WHALLEY PARISH COUNCIL

Planning Application No: 3/2023/0652

Proposal: Regularisation of installation of new wooden boundary fence to front garden.

Location: 5 Brookes Lane Whalley BB7 9RG

We have also taken some photos of our wall/fence:

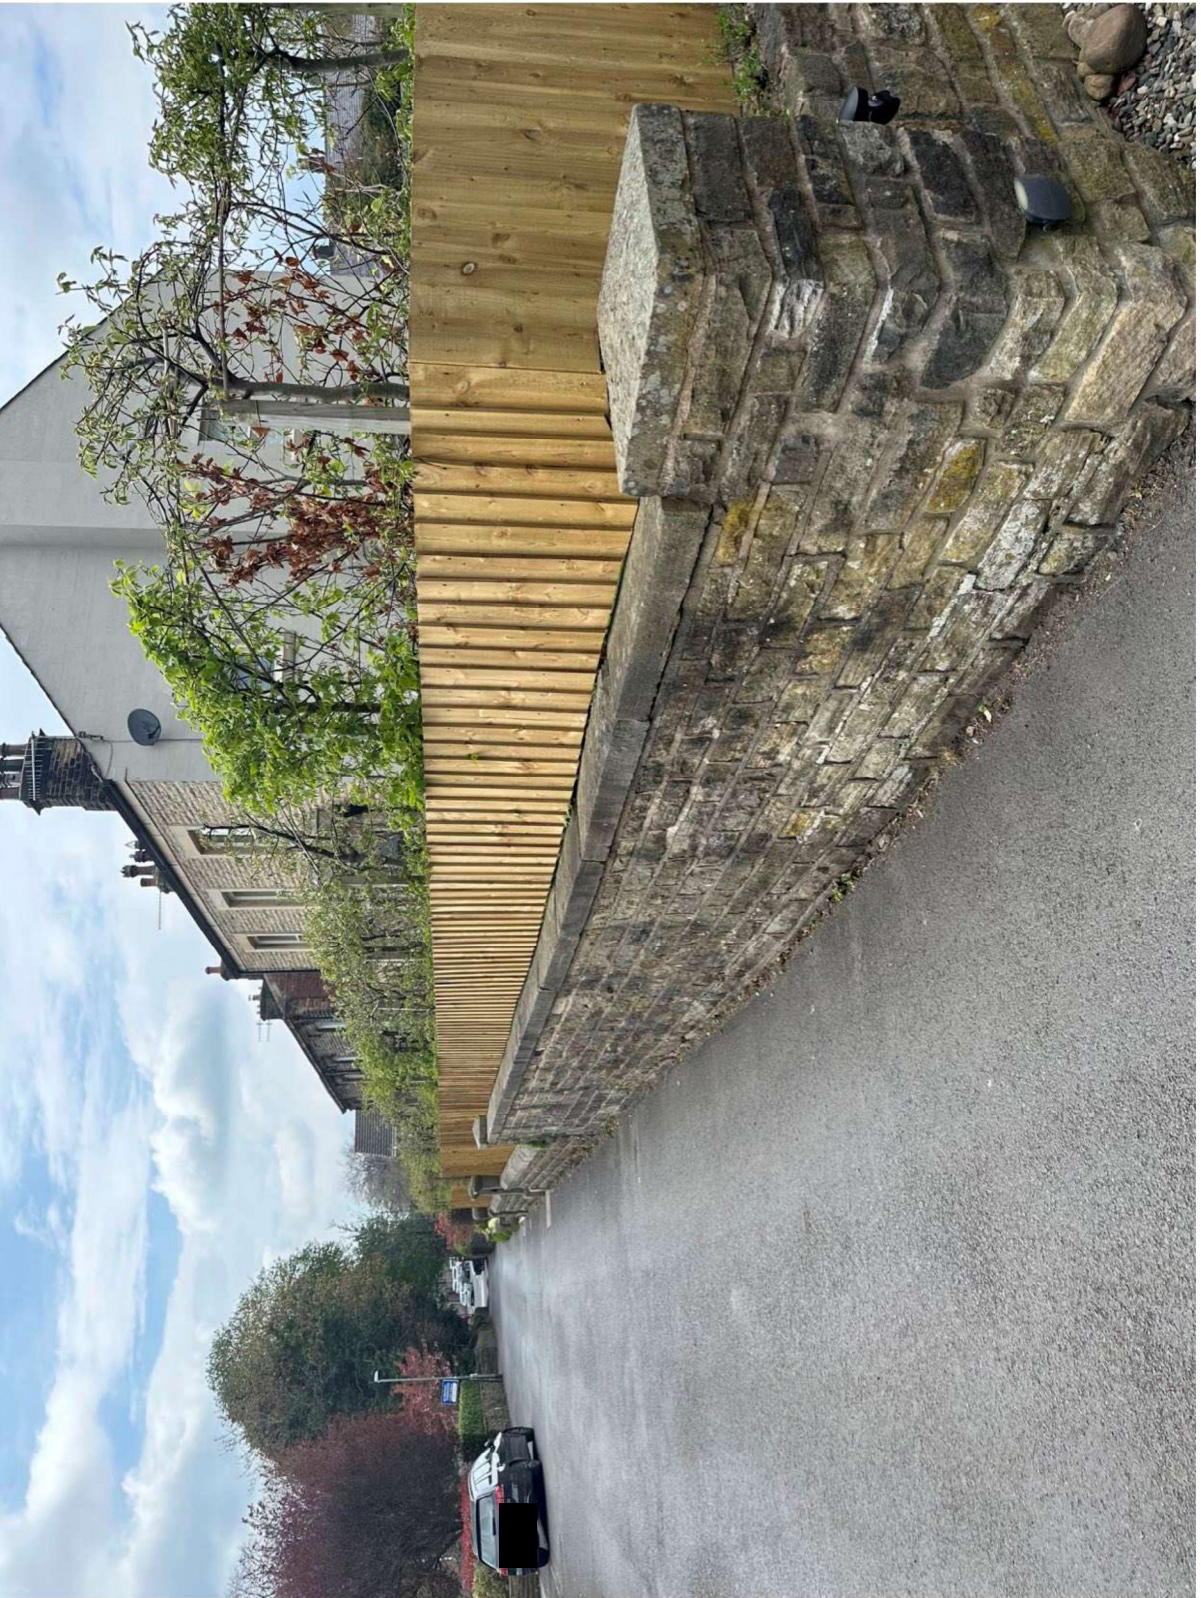
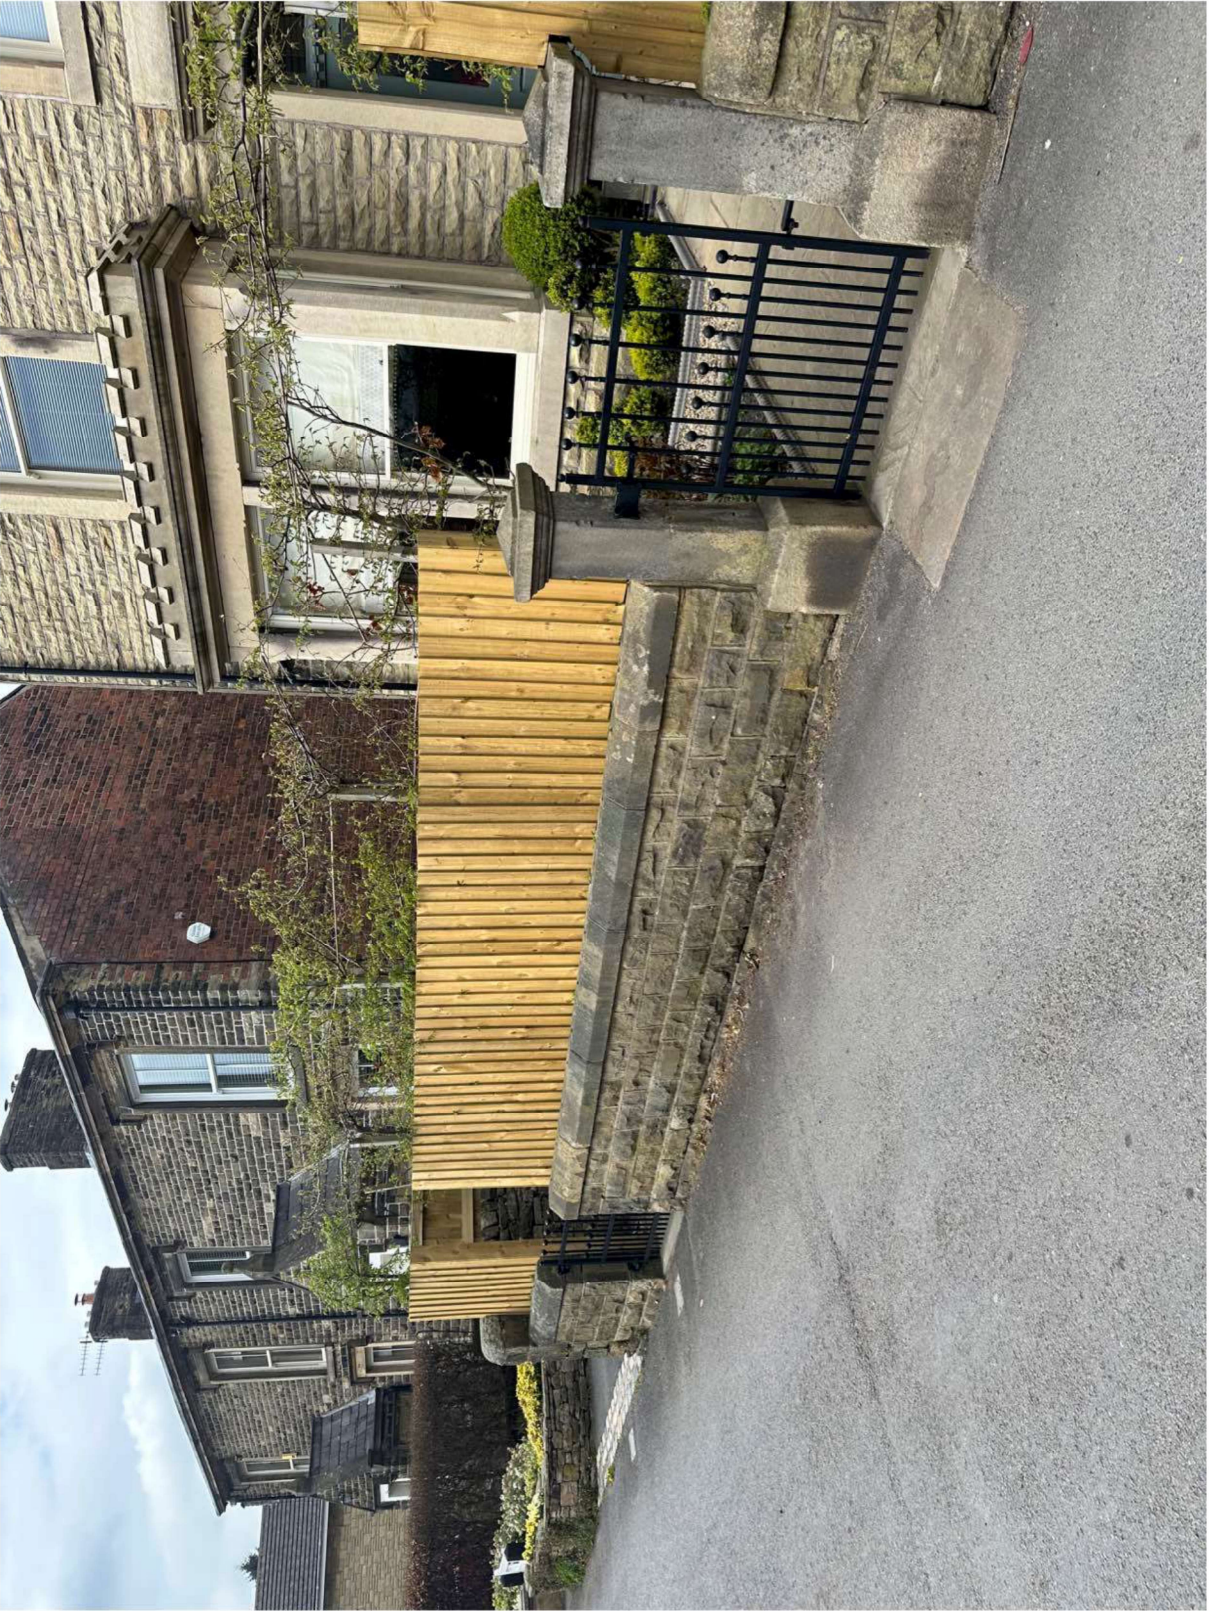
Whalley Parish Council object to the above planning application on the grounds of height and material which are out of character and inappropriate for the conservation area.
